Town & Country Planning Act 1990 (as amended)
Town and Country Planning (Development Management Procedure) (England) Order 2015
Application for approval of details reserved by conditions imposed under planning appeal
APP/C3810/A/13/2199149 (EP/83/12) relating to Condition No. 7 (Surface water drainage)
The Martlets Sea Road, East Preston,

Arun District Council have decided to **REFUSE details reserved by condition for the following reasons:**

Proposed Surface Water
Soakaway (To serve roof
slopes only)

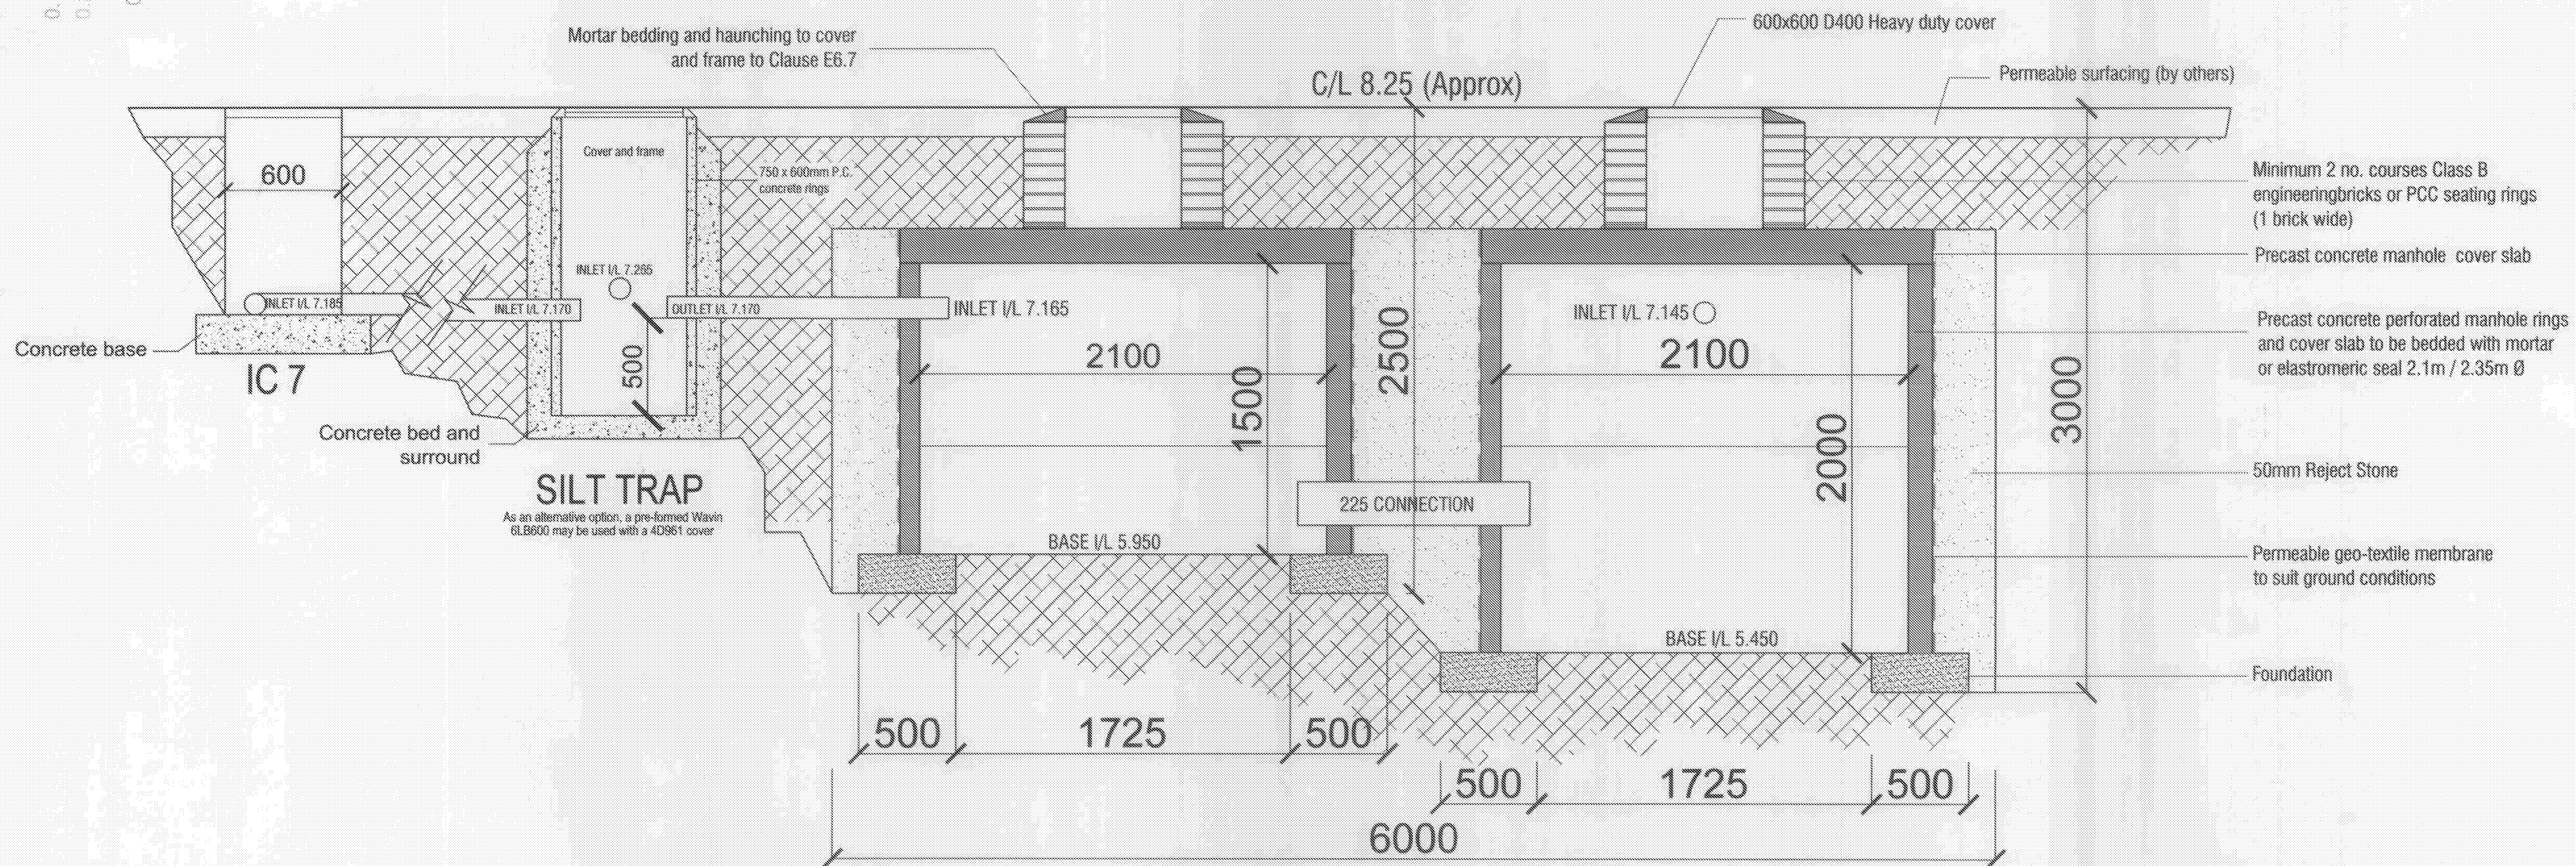
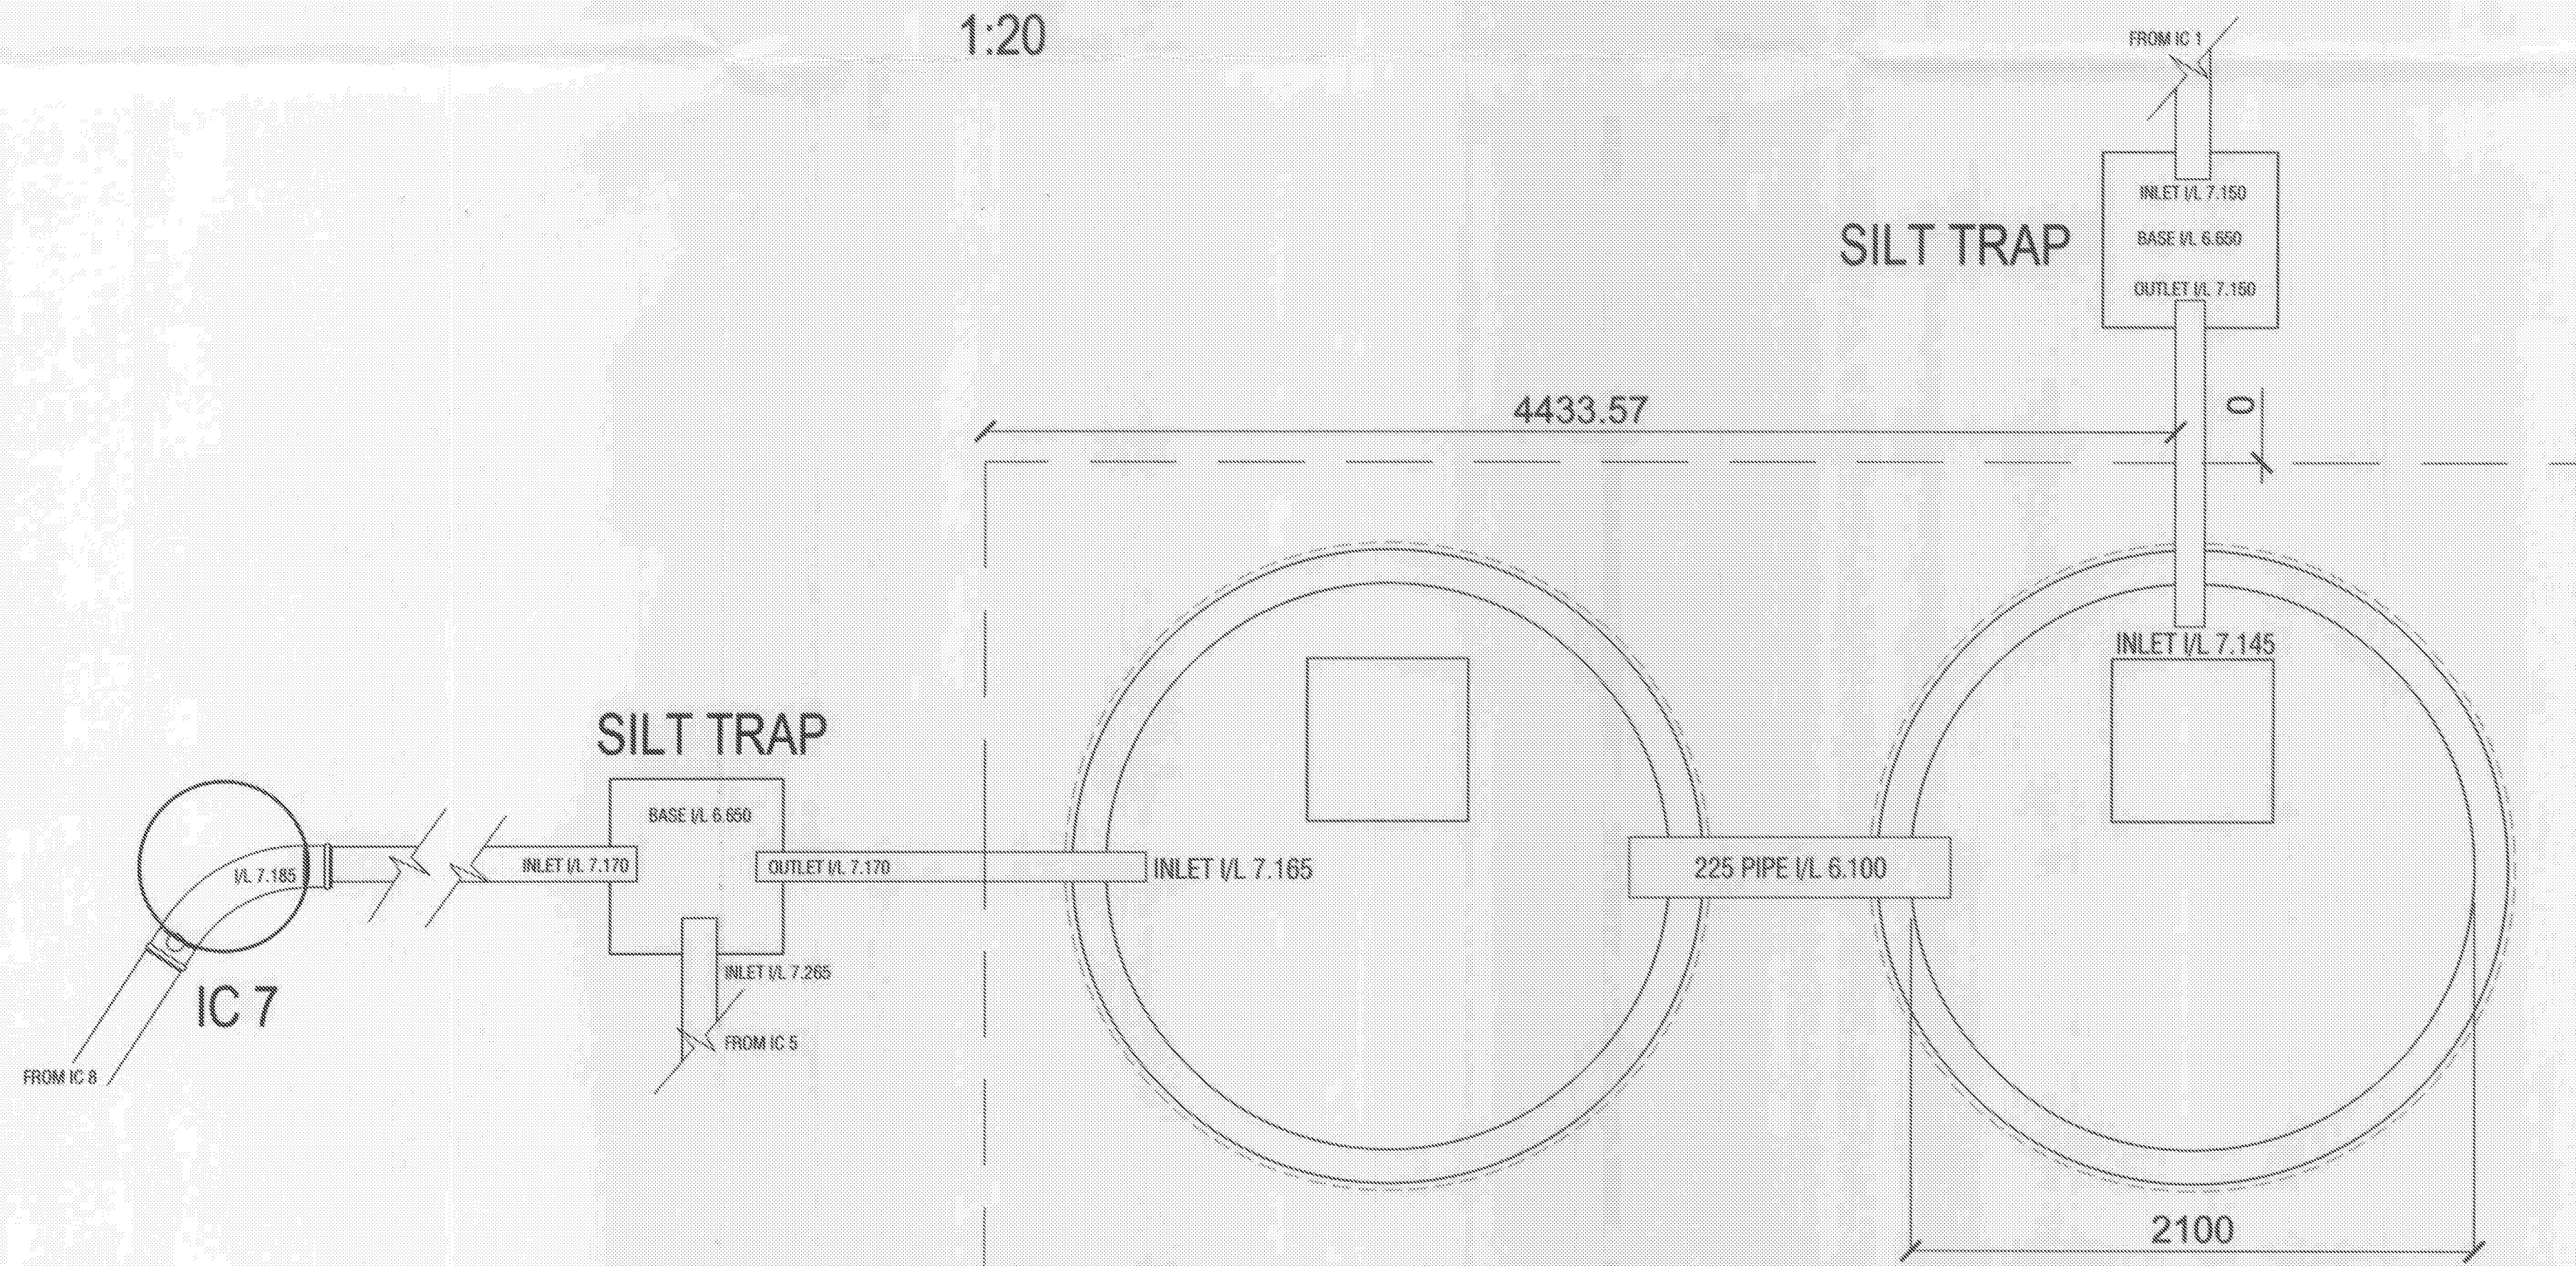
This condition cannot be discharged until such time that the following information is submitted to support the design;

1. Winter groundwater monitoring data.
2. Winter percolation testing to BRE 365.
3. Hydraulic calculations to confirm that the 1 in 100 year storm event + 30% allowance for climate change, can be accommodated within the site.
